ALTERNATIVE DESIGN EXCELLENCE PROCESS PROPOSED MAJOR PROJECT 45 MACQUARIE STREET, PARRAMATTA

Design Review Panel

Report One.

45 Macquarie Street, Parramatta.

i. Solar & Daylight Analysis

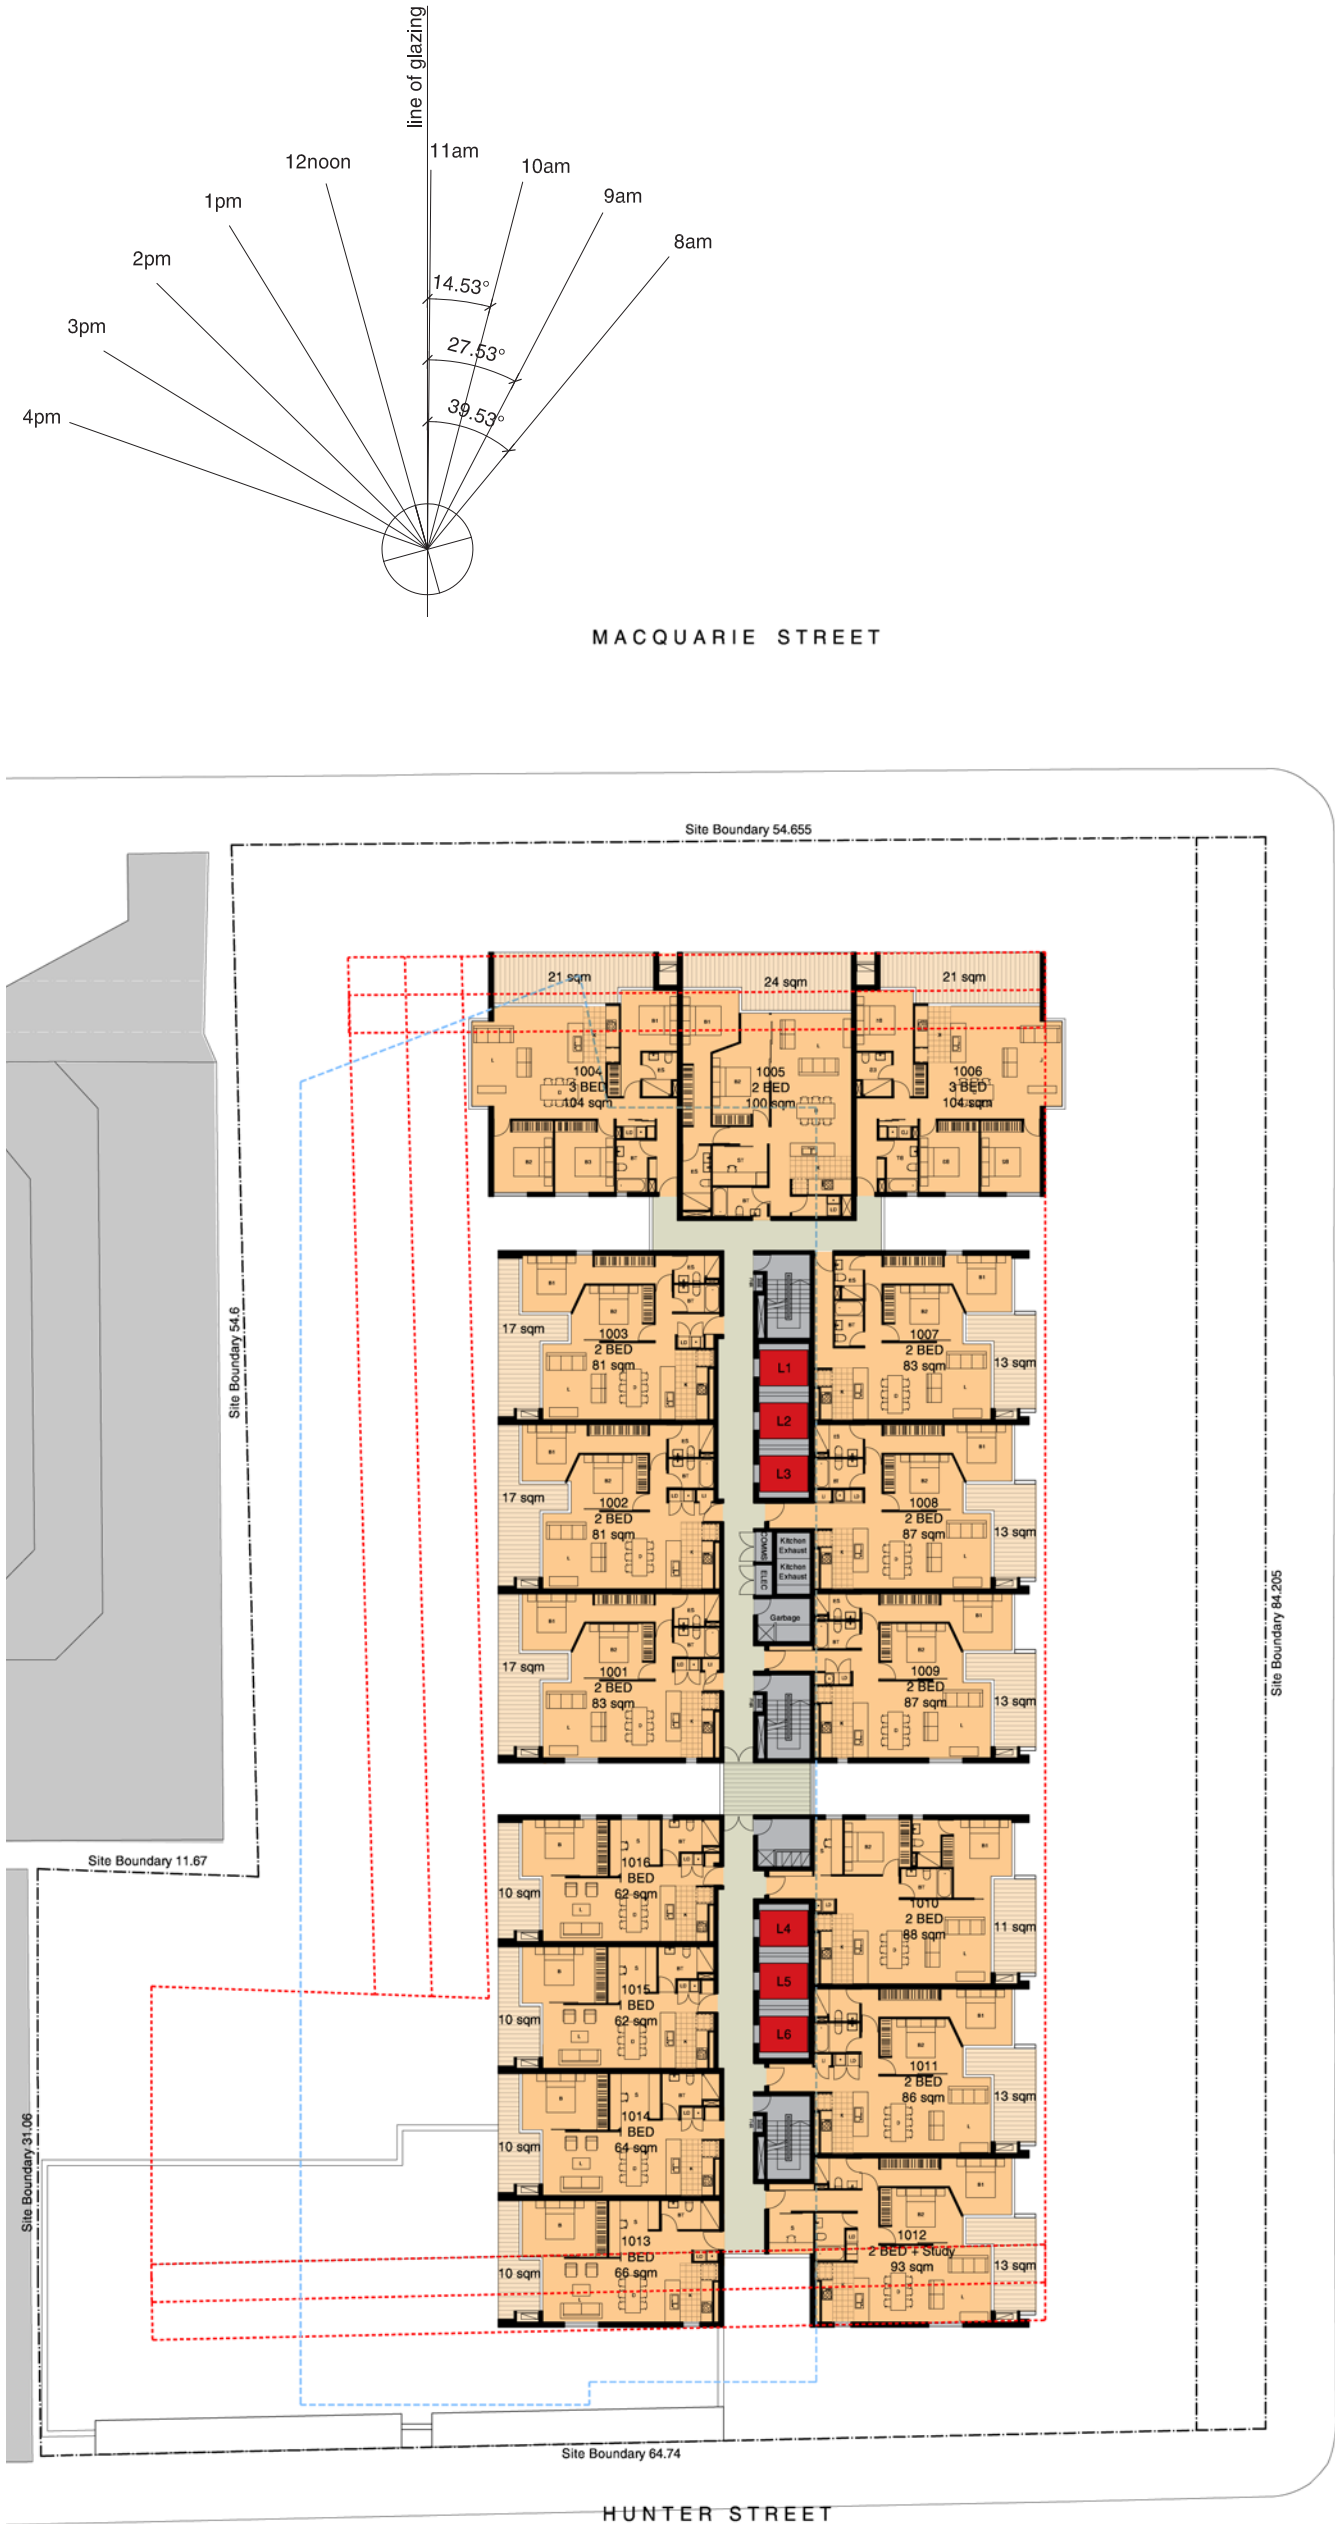
The sunlight access to the eastern façade also does not appear to meet the requirements of the RFDC as at 10am only a very small amount of sunlight enters the living room. This requires further justification, it may be helpful to examine the sun access at 7.30am.

ii. Cross-Ventilation

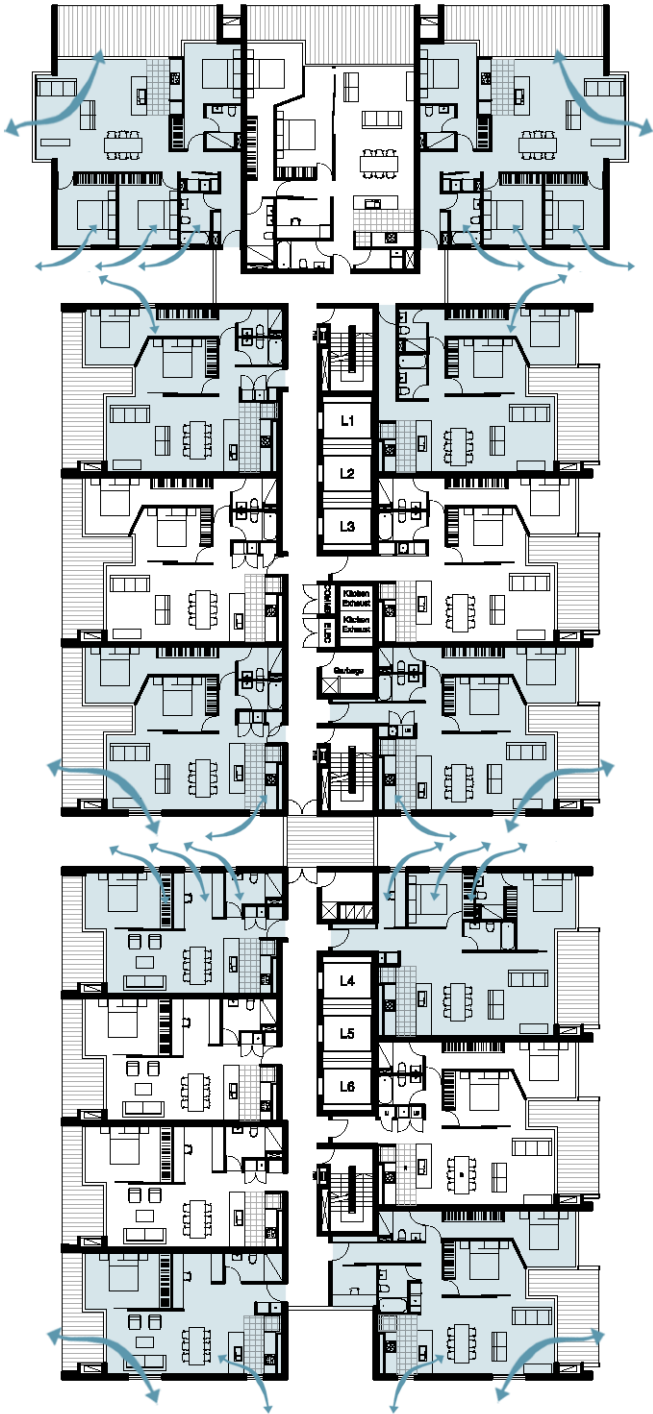
In particular, the light, acoustic and ventilation characteristics provided by the “slots” require justification. The panel agrees that the “slots” should be a minimum of three metres wide and this depth may not be sufficient and requires further justification. Some of the internal apartment plans do not appear to take enough advantage of the slots. The panel believes that the RFDC building depth and natural ventilation paths are not strictly complied with and is therefore not convinced that natural ventilation amenity is provided. The additional building depth may also effect the availability of natural light. In addition, where bathrooms and kitchens are adjacent to the slots they should be provided with windows. Where bedrooms have their only window into the slot it should be designed to enable easy view out of the slot by the occupant. All windows into the slots, including the common area windows should be openable to provide

natural ventilation. This may require fire engineering advice and this should be incorporated prior to the submission of the proposal for approval.
